Subject: RE: AL/126/21/PL Ryfield's Farmhouse

Engineers comments on surface water drainage;

Subject: AL/126/21/PL Ryefields Farmhouse

Fig 4 - Proposed Site Plan

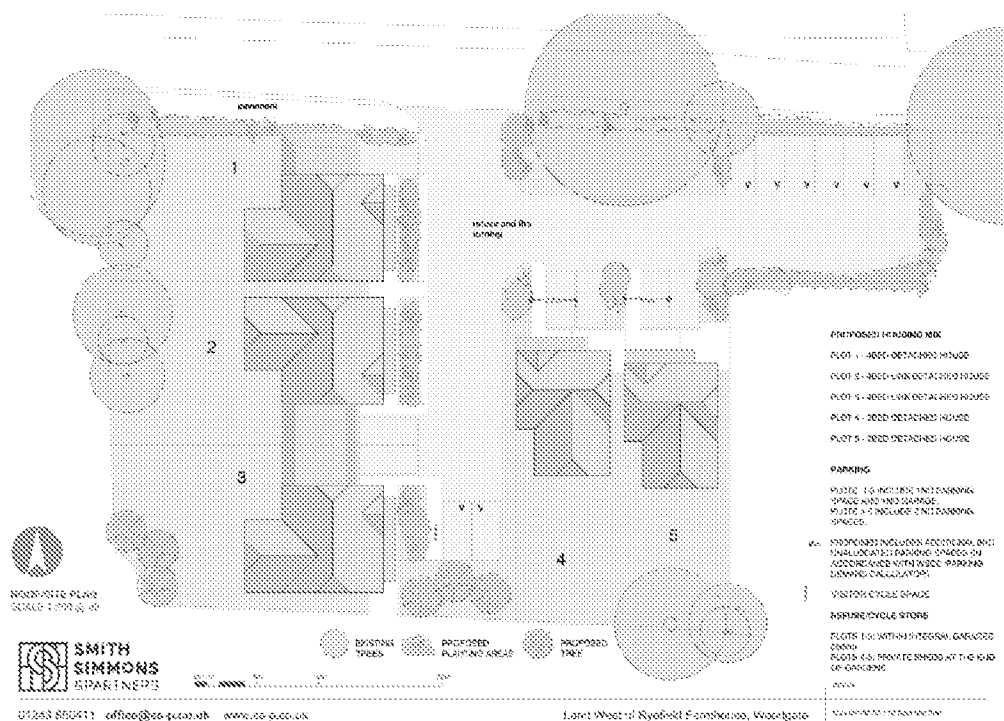
The developer will be encouraged to incorporate permeable paving within the development to help provide attenuation and water treatment. Please note that the current drainage scheme does not indicate any presence of permeable paving.
